Subject: BN/23/18/PL

Regards the application at 37 Hill Lane, all previous points re over -development and loss of light still stand. Specific to drainage submission.

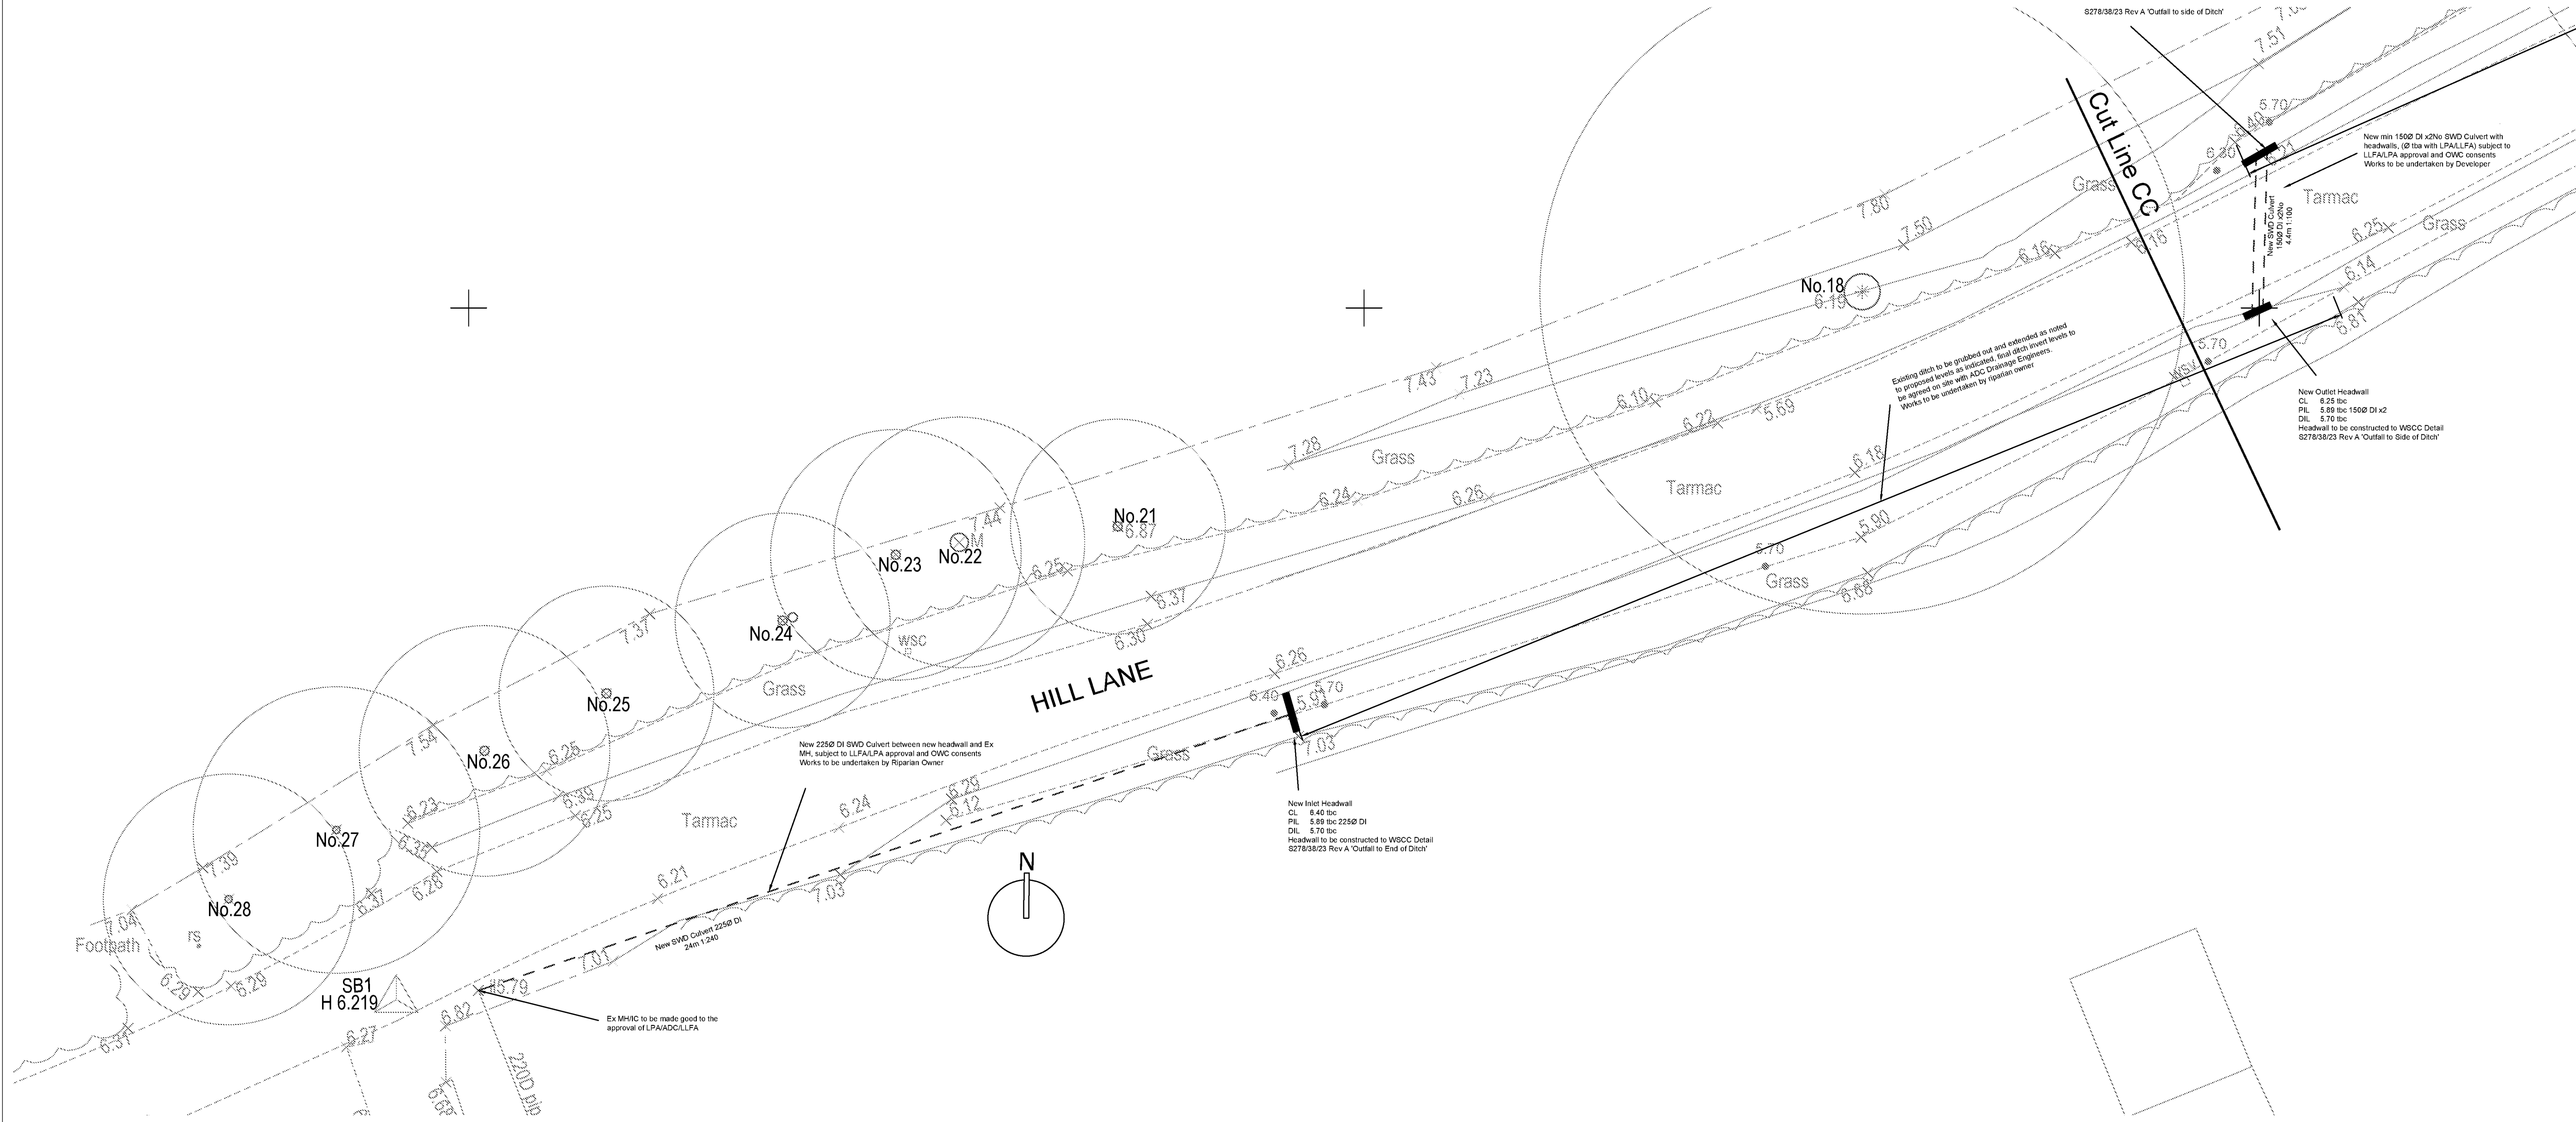
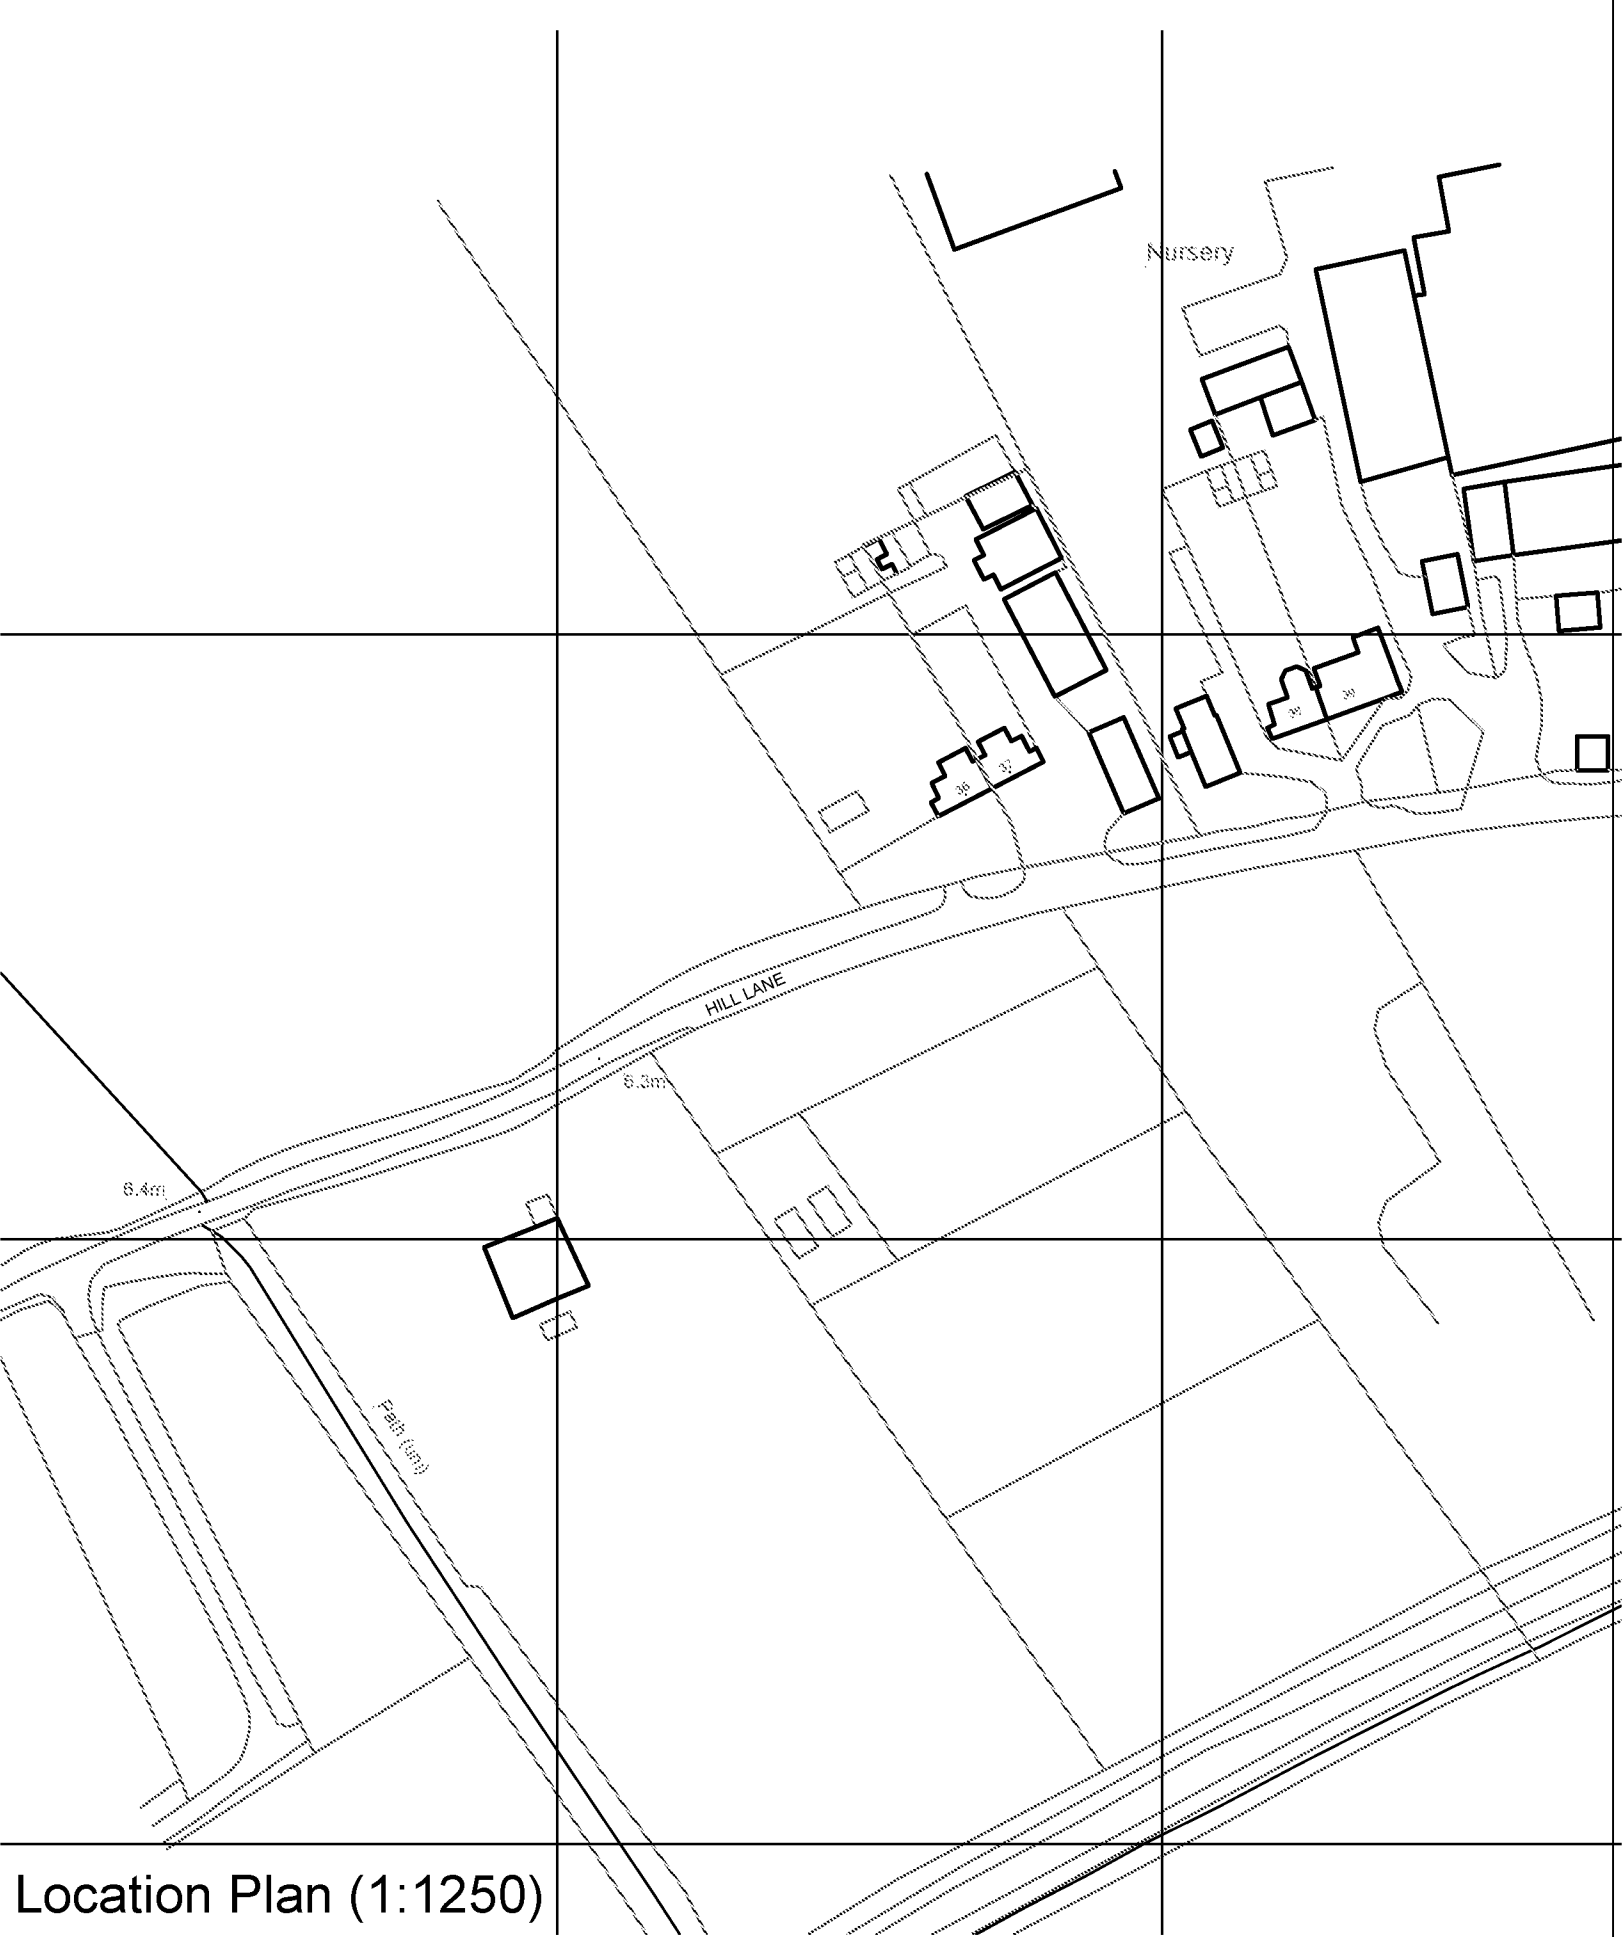
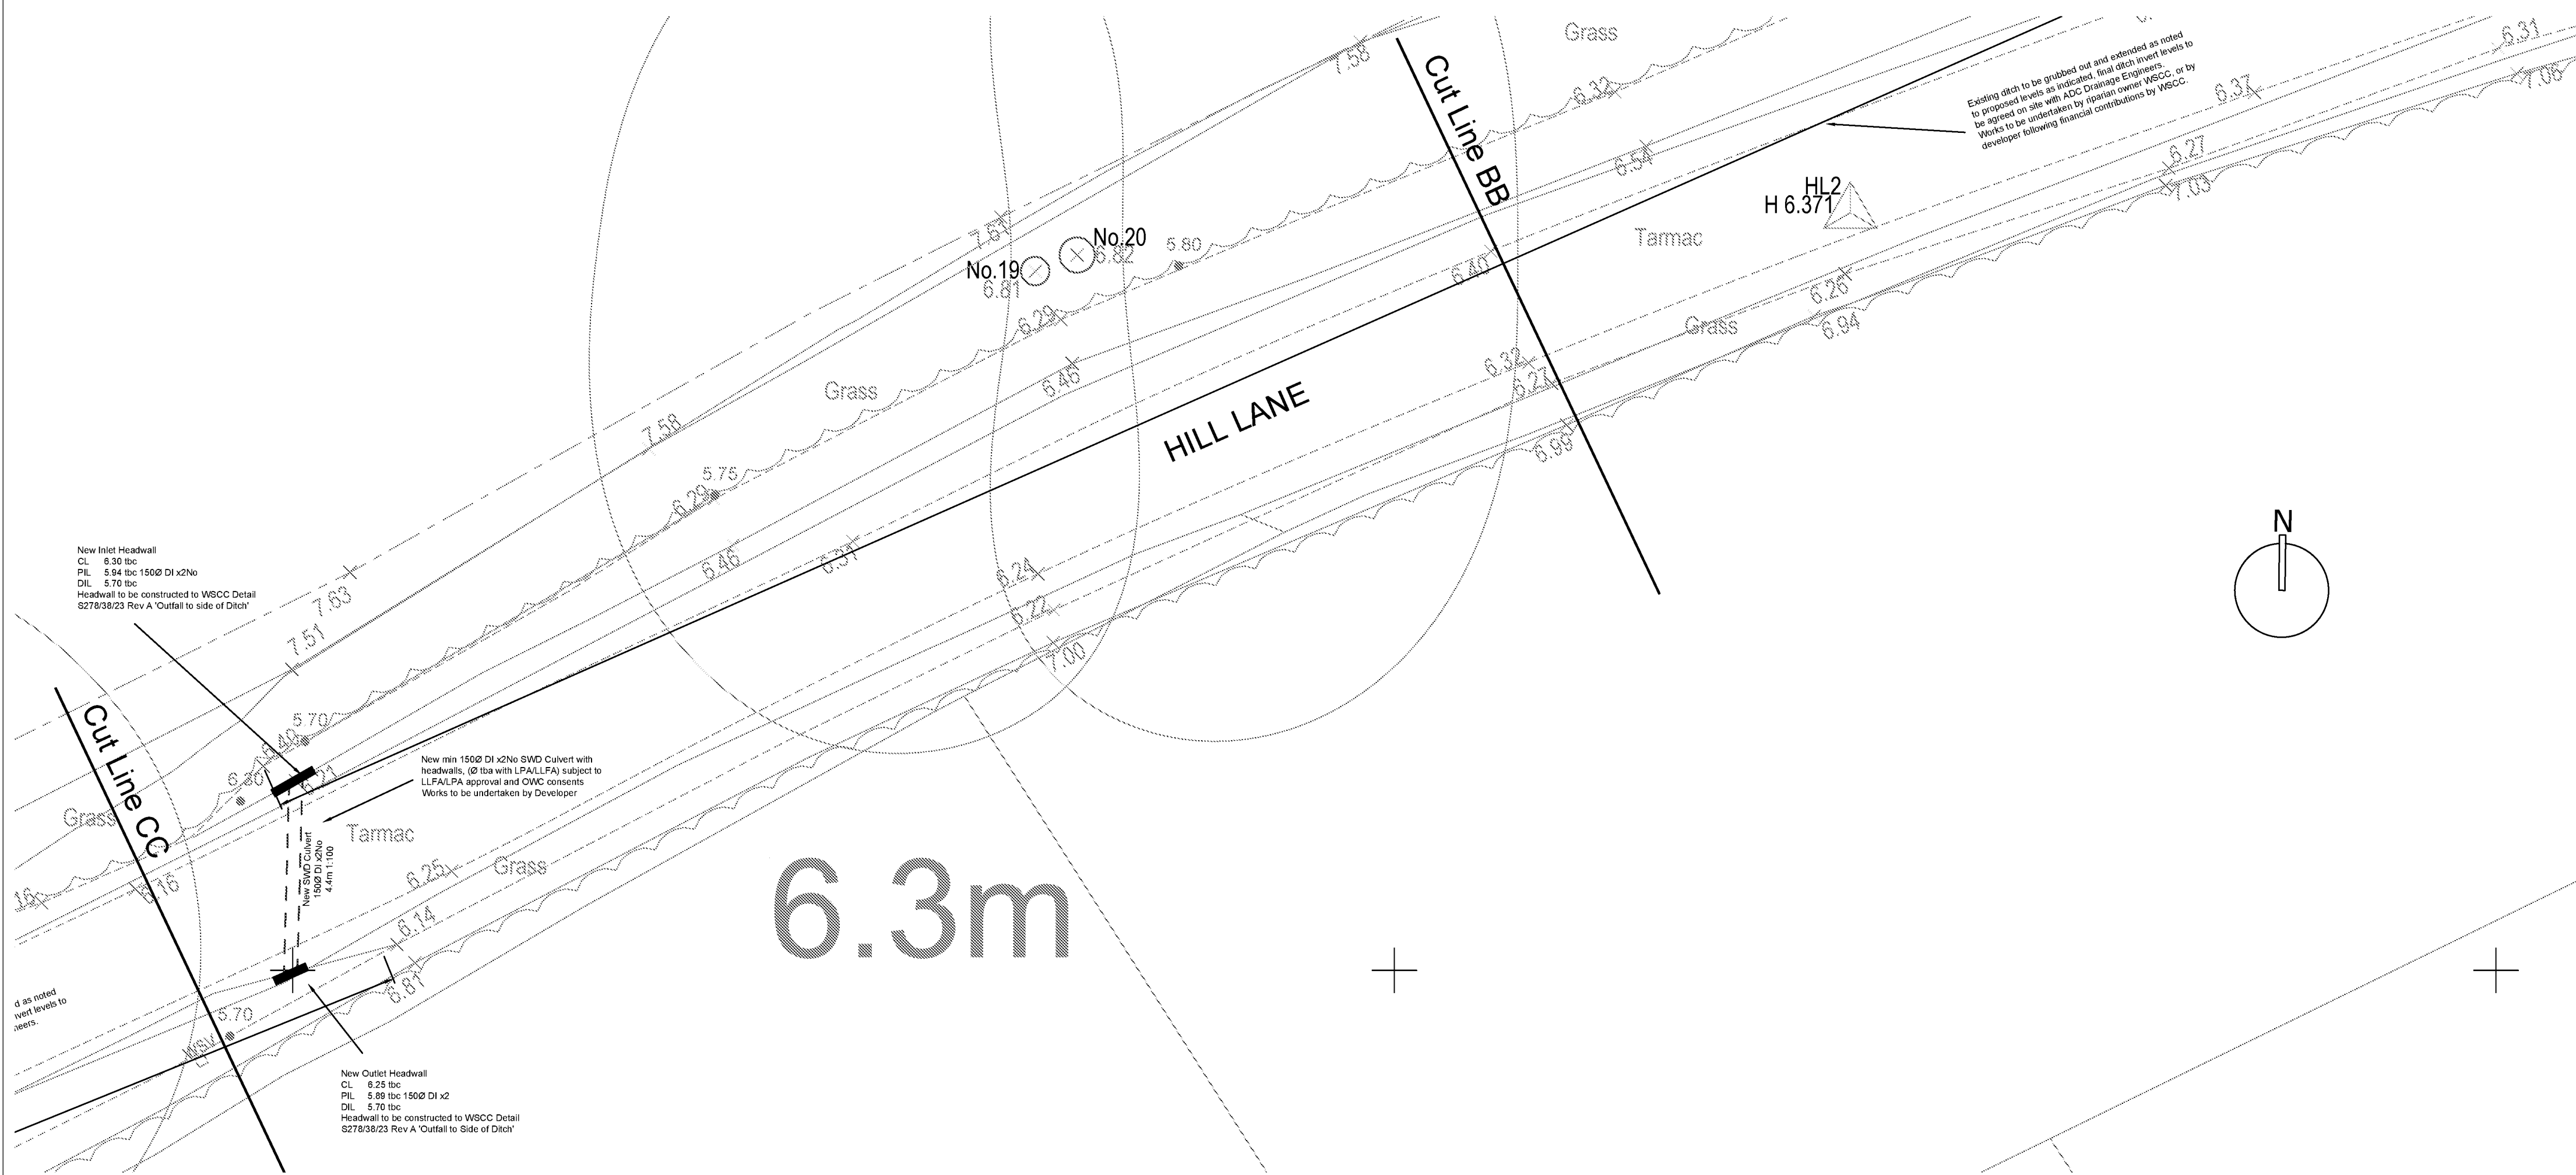
5.2.6 & 5.2.10 Not sure where this comes from . To my mind not feasible/possible as the application endeavours to talk up a 'system' that may have existed, which many with longer knowledge than me contest (I've only been here 27 years). Why in Appendix B is the proposed NEW ARRANGEMENT going to cross the road and run on the Southern side to carry a NEW, EXTRA, ADDITIONAL Load. This isn't riparian
